From: Amanda Scholes on behalf of Planning.Responses
Sent: 23 March 2018 08:23
To: Planning Scanning
Subject: FW: Planning Consultation on: AL/8/18/PL

Comment from Greenspace

Registered: 26th January
 2018
Site Address: Land between 8 & 10 Barnett Close Eastergate
 PO20 3UW
Grid Reference: 494230 105601
Description of Erection of 2 No. 2 bedroom dwellings with
Works: associated parking & landscaping.

location plan &
proposed site plan

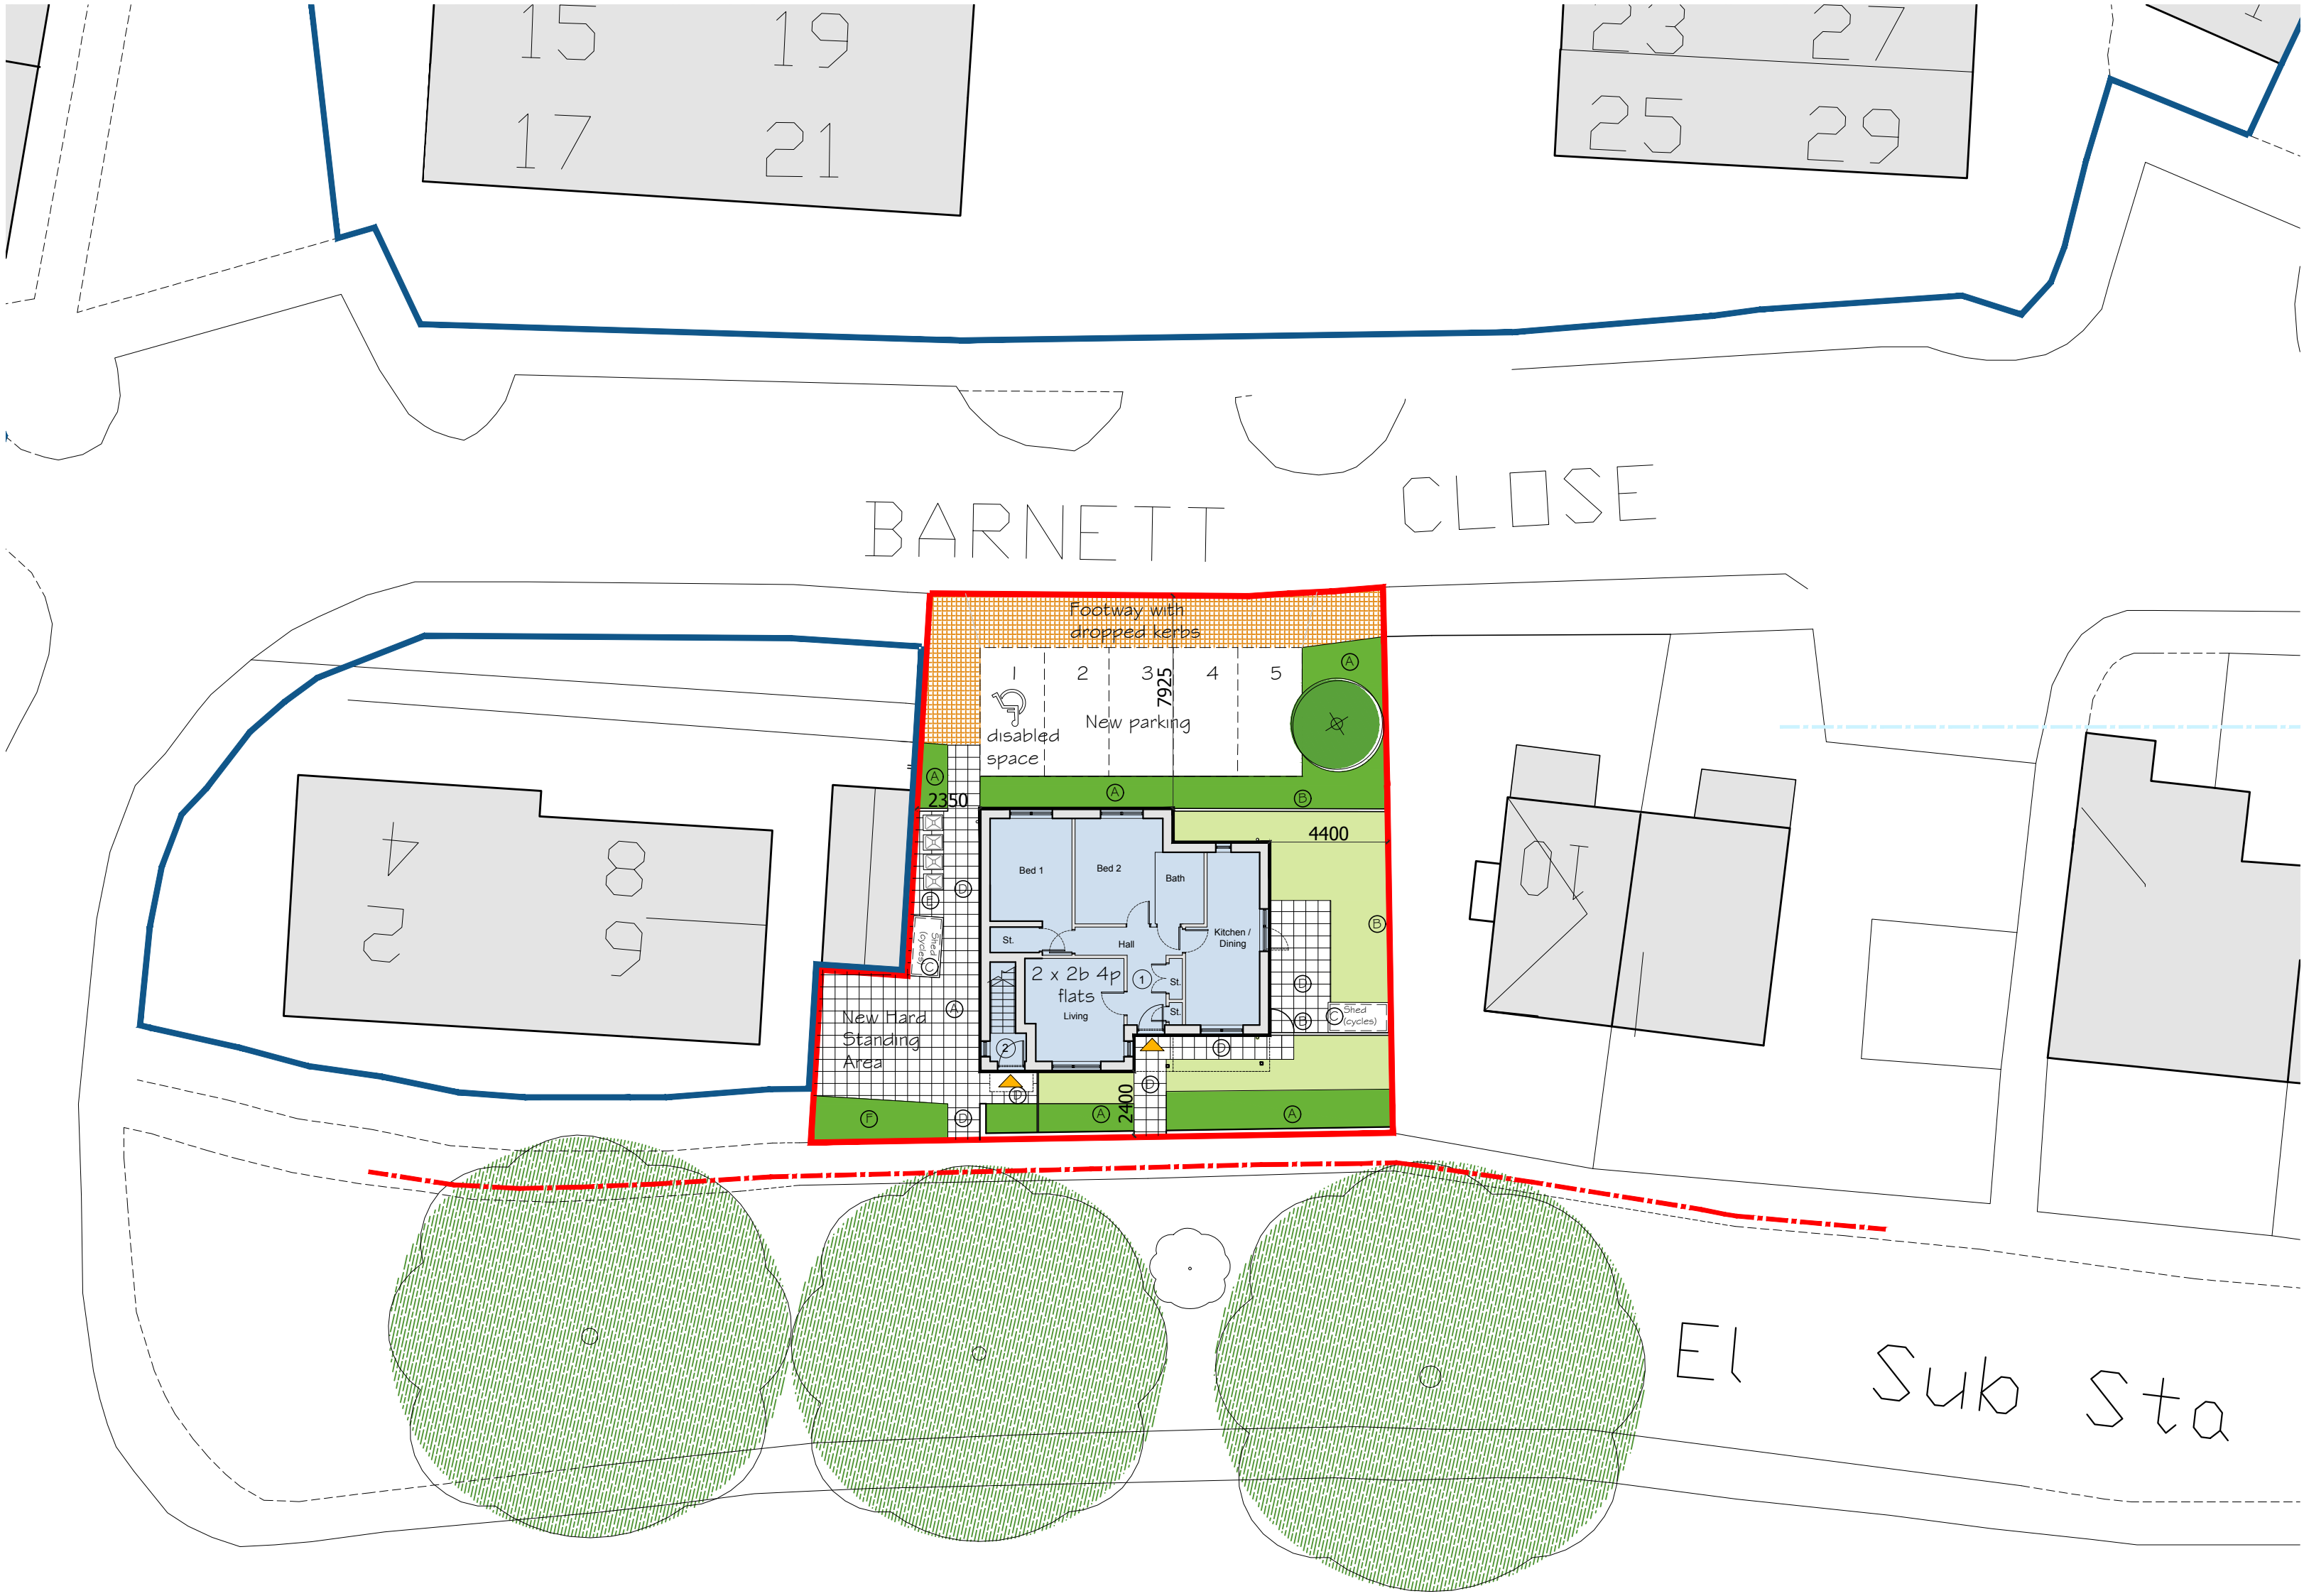
The proposals put forward in this application for the infill of housing will have no perceived landscape impact. The existing landscape features, presently include an area of hard standing with very minimal existing vegetation and where existing has been considered and incorporated appropriately. With this being a smaller development of less than 7 dwellings then open space on site is not a consideration. However development of any kind should consider greening to add to the proposal and to enhance the setting. Indicative landscaping has been shown, but in addition to this a detailed landscape scheme will need to be proposed that will maximise the biodiversity of the site with the inclusion of mixed ornamental and native species for the retention of a variety of habitats. The landscape proposals will need to be shown in plan form detailing species choice, planting densities and size at time of planting.

The existing vegetation, must be protected during construction where it is to be retained. There are no tree protection issues associated with this location.
